Date: 11 December 2023
Our Ref: 23/01060/CLEUD
Please ask for: Simon Lems

Invalid Application

Proposal: Application for a certificate of lawfulness for an existing rear dormer
Location: 36 Lancaster Close Adlington Chorley PR6 9RA
Reference: 23/01060/CLEUD

REAR ELEVATION

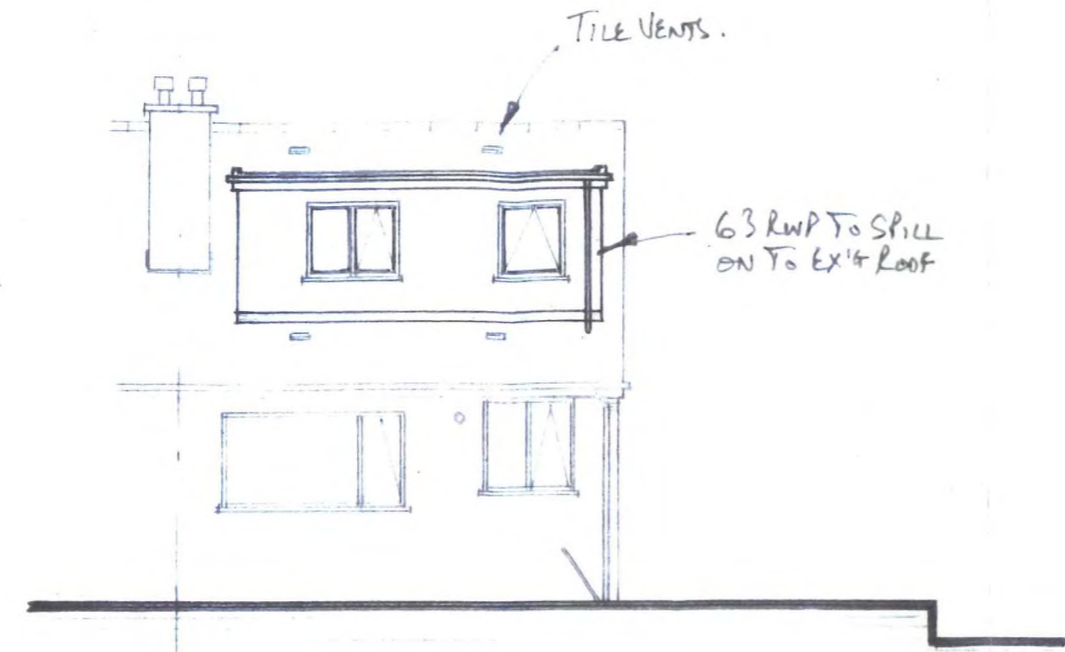
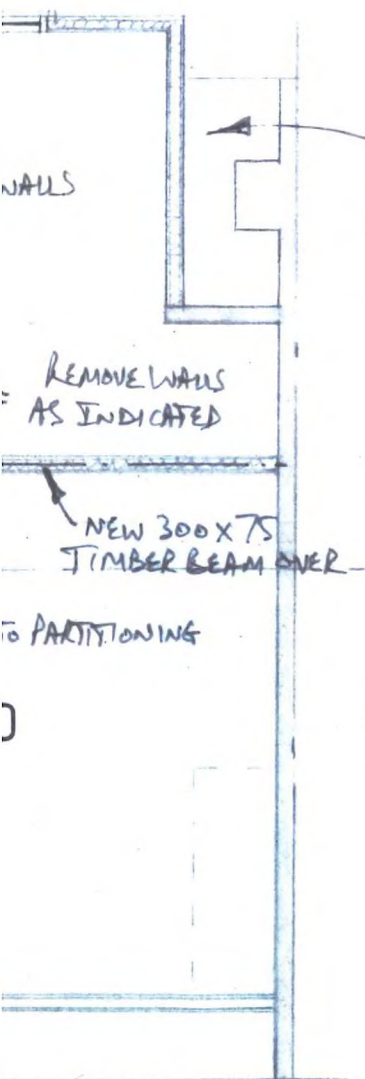
1. Existing Elevations (at a scale of 1:50 or 1:100).

Please could you provide plans at a scale of 1:50 or 1:100 showing the existing roof with the dormer extension.
